Your Ref: OWPC19458
Our Ref: AL/76/18/HH 26-06-2018
Please ask for:
Amber Willard

External garage extension to include a storeroom.

Mayaro House Hook Lane Aldingbourne

PROPOSED DETAILS

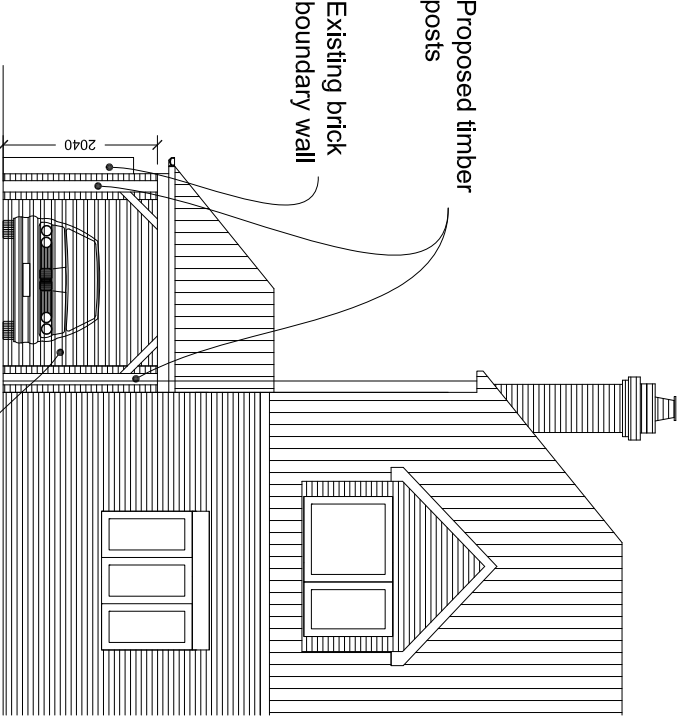
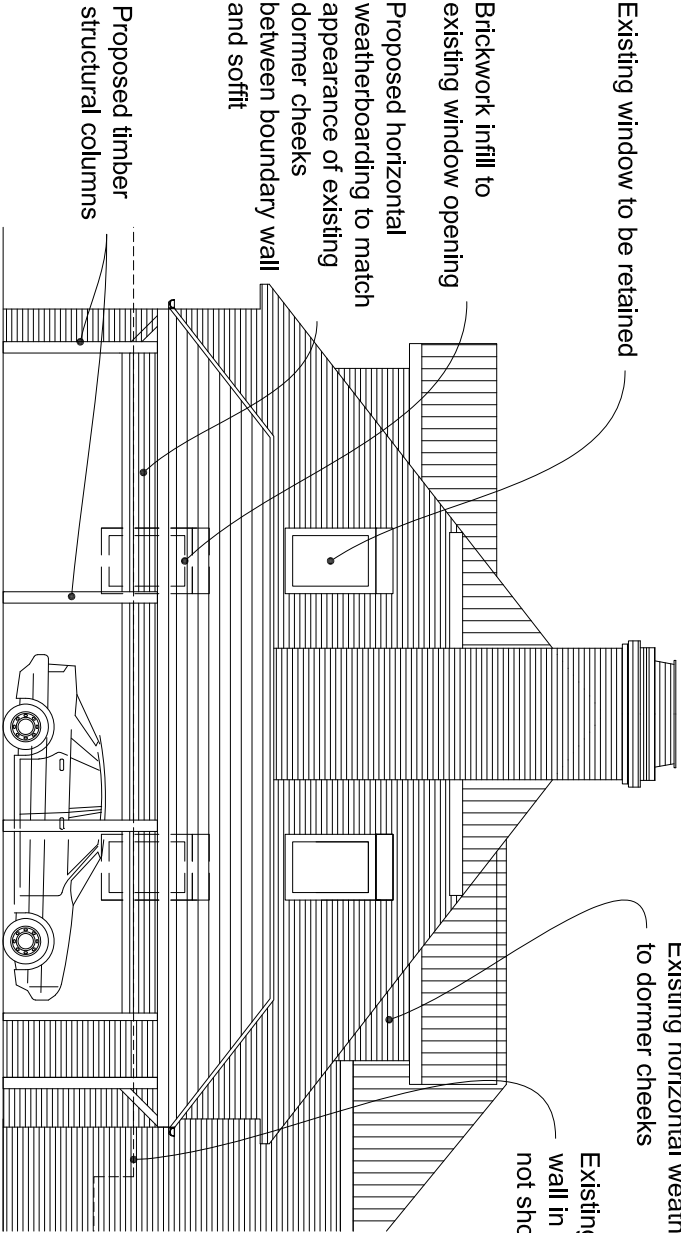
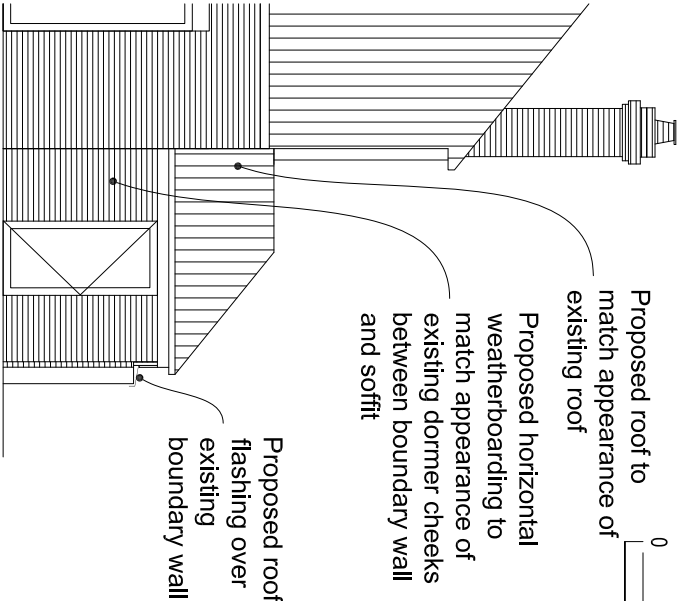
The proposed roof appears to overhang the boundary wall. This new driveway already affects the splay of the track that runs alongside this property by forcing exiting cars turning left into the oncoming traffic on the other side of the road.
